Recommendation Report for Planning Permission for Works or Extension to a Dwelling

REF NO: BR/293/21/HH

LOCATION: 73 Nyewood Lane
Bognor Regis
PO21 2SD

PROPOSAL: Two storey side and rear extension, rebuilding of existing conservatory and demolition of existing garage.

Elevations

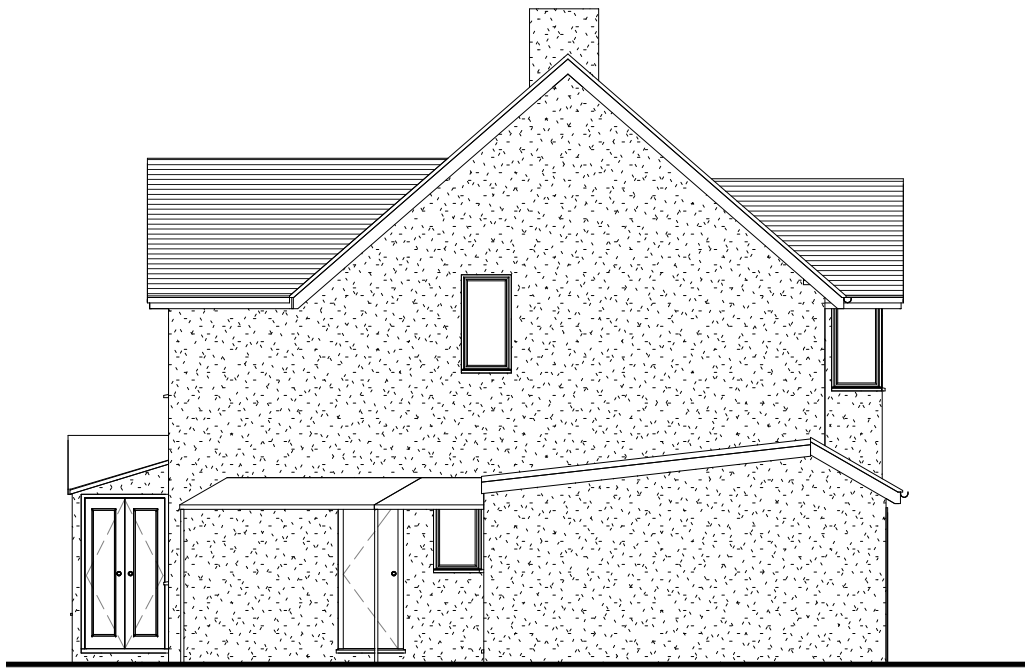
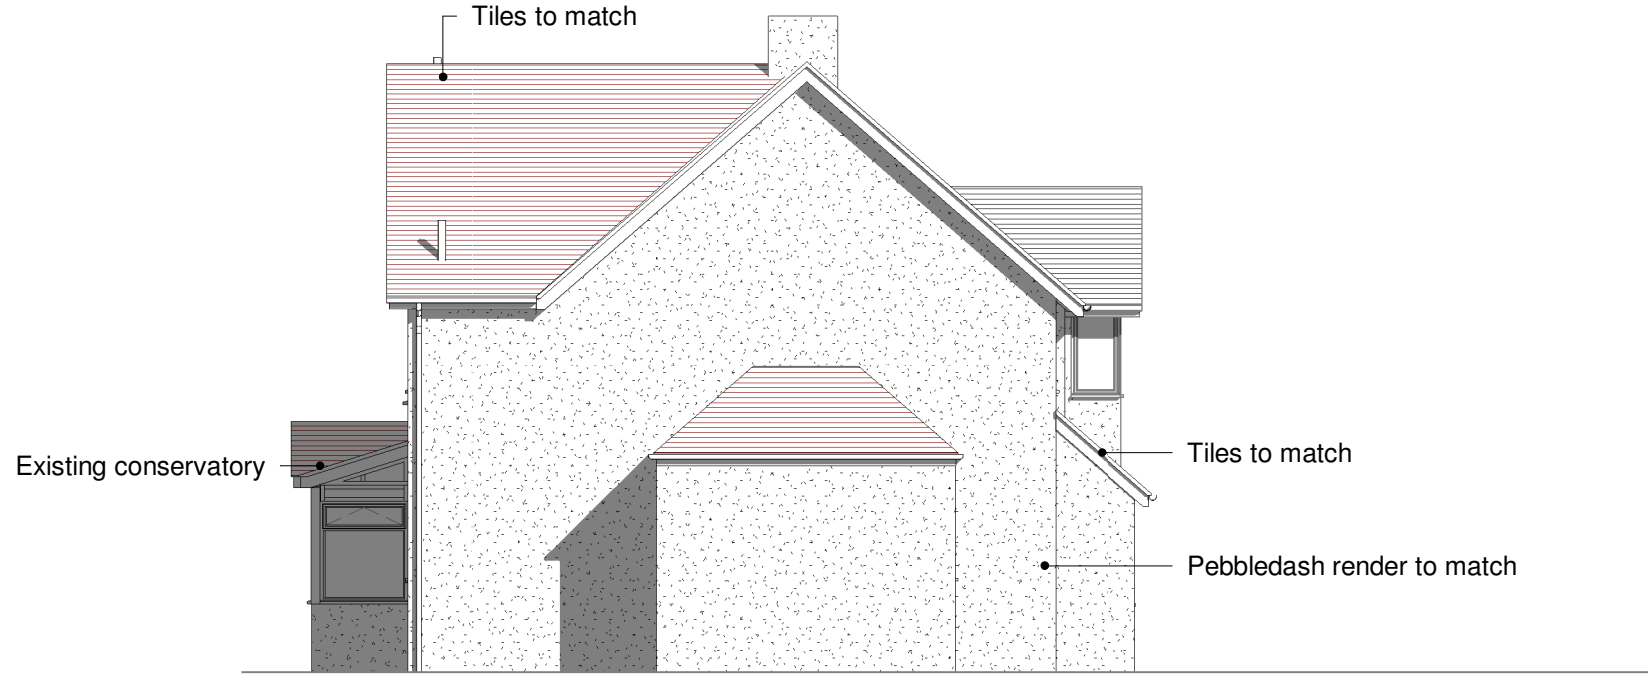
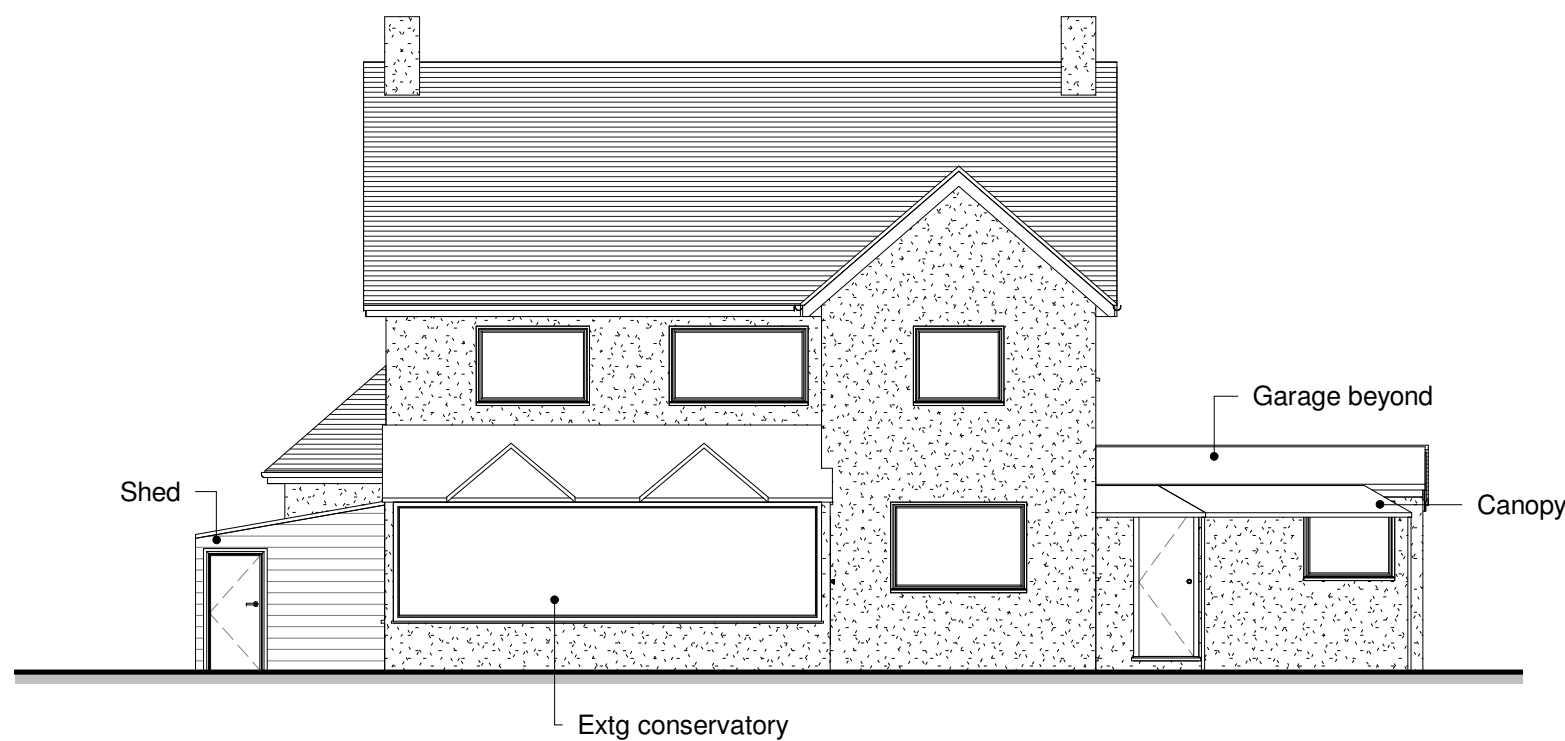
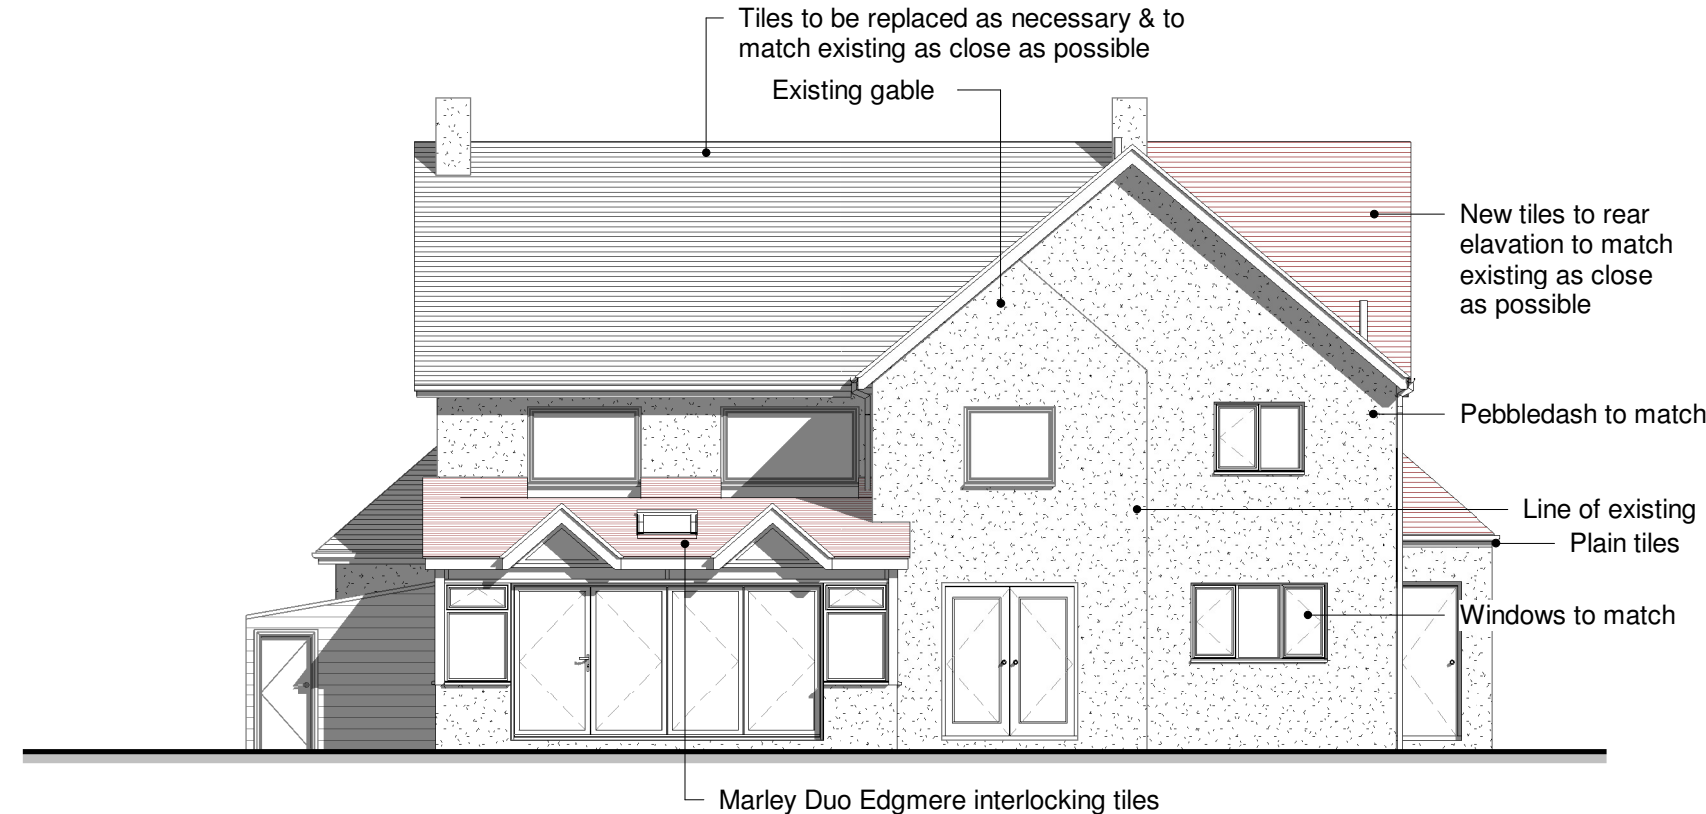
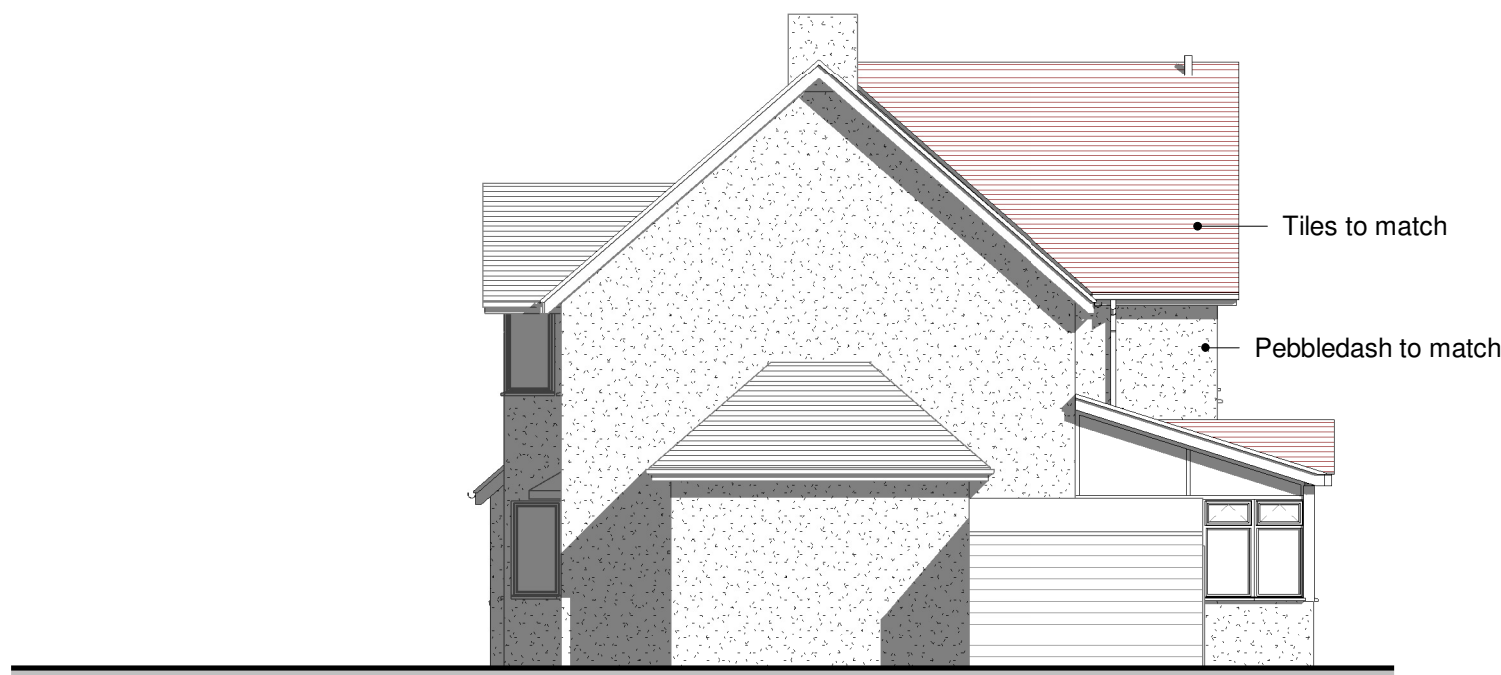
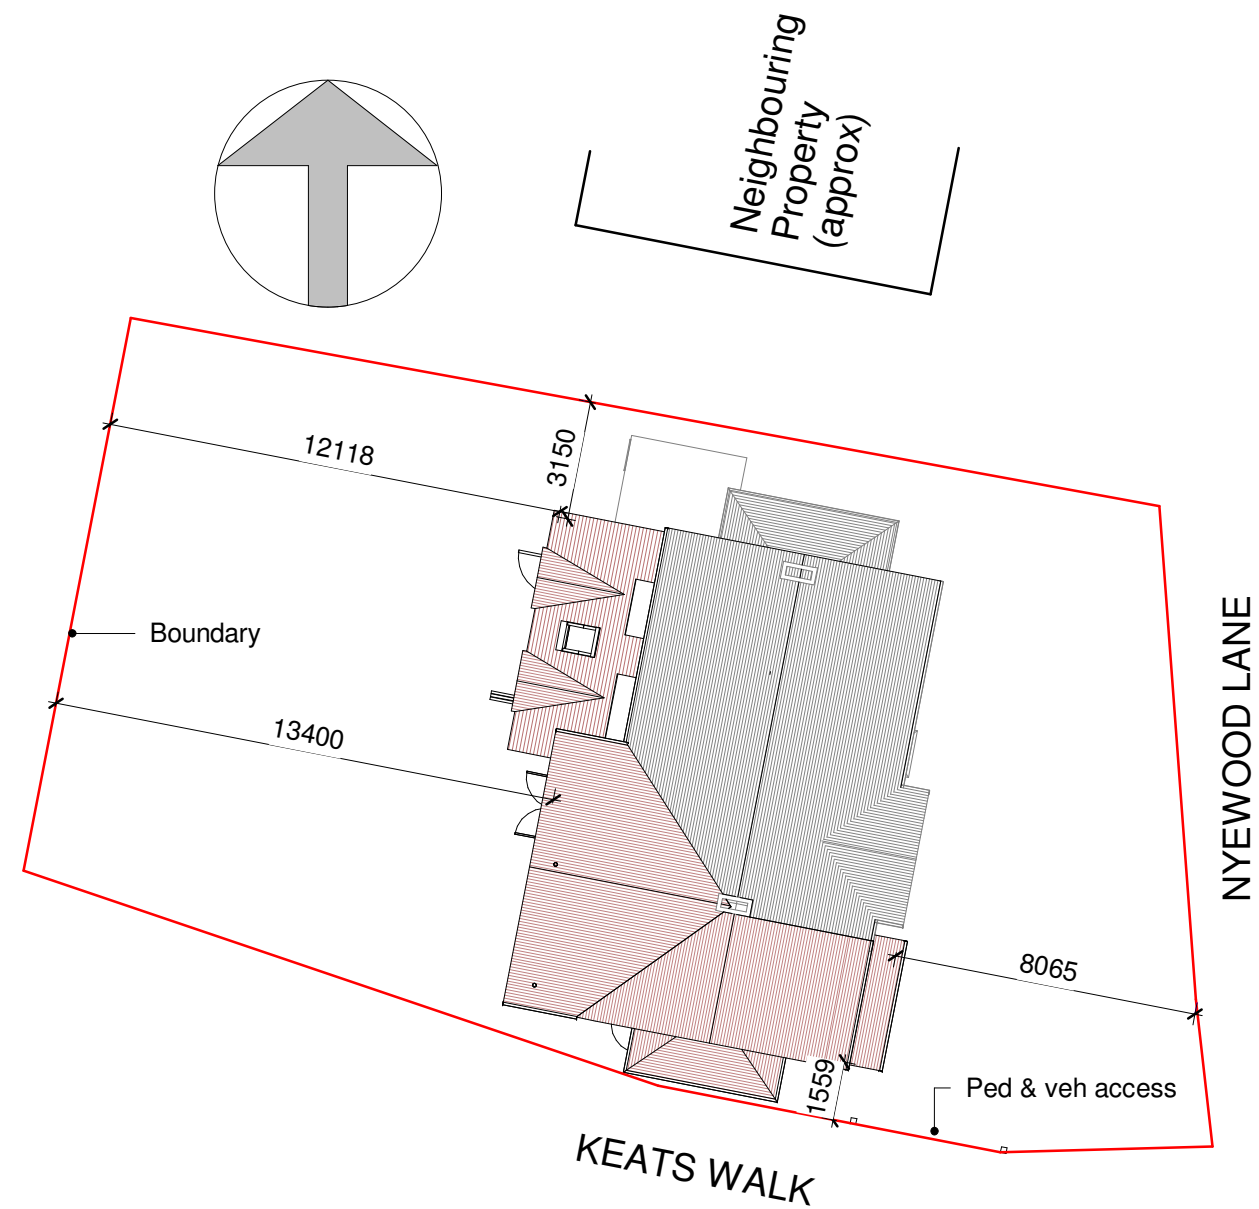
The proposal will have a gable roof to the front and rear, joining with an existing rear gable roof addition. The development appears well designed, integrating well in terms of its scale and appearance. Materials used will match the host dwelling featuring pebbledash and tiles which is sympathetic to the host dwelling.

The Arun Design Guide states 'Side extensions should in most cases be set down from the existing roof ridge height by a minimum of 0.5 metres' The proposal is not set down although remains to appear well integrated. 'The building frontage should be no greater than 70% of the existing building'. 'Responds to existing building design in terms of roof pitch'. The proposal complies with this being appropriate in size and design.

There will be a lean to roof to the front of the garage which is located to the ground floor of the extension, although this extends largely in line with the principal elevation of the property. There is also a modest single storey addition to the side elevation which is appropriate in scale meeting with the boundary to the south.

The surrounding properties are varied in appearance and whilst the proposal will alter the appearance of the dwelling, it will not result in the dwelling appearing adversely out of character.
